Tracy Bellamy - Epping to Thornleigh Third Track Proposal - Application number SSI 5132

From: "Mel and Tony" <meltonran@aapt.net.au>
To: <plan_comment@planning.nsw.gov.au>
Date: 30/10/2012 10:39 AM
Subject: Epping to Thornleigh Third Track Proposal - Application number SSI 5132
CC: <office@hazzard.minister.nsw.gov.au>, <philip.ruddock@aph.gov.au>, <office@smith.minister.nsw.gov.au>
Attachments: Extra Track 001.jpg

Epping to Thornleigh Third Track Proposal. Application number SSI 5132.

Figure 5.6 Cross-section and elevation - New Cheltenham Station concourse building
Note: Indicatively added to future design

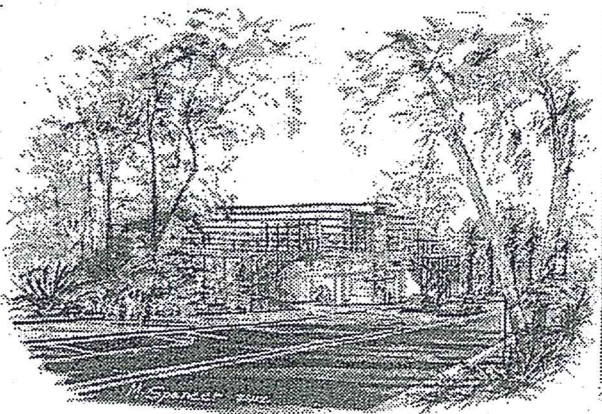
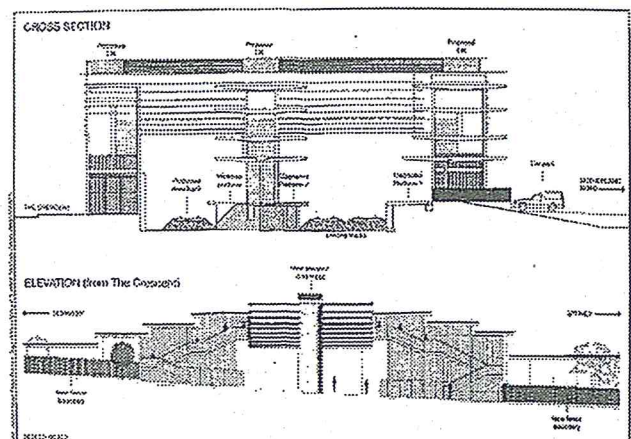
- The proposed redevelopment of Cheltenham Station shows no regard for the HCA. The visual impact of the proposed 13m high glass and steel concourse is totally unacceptable in this HCA.
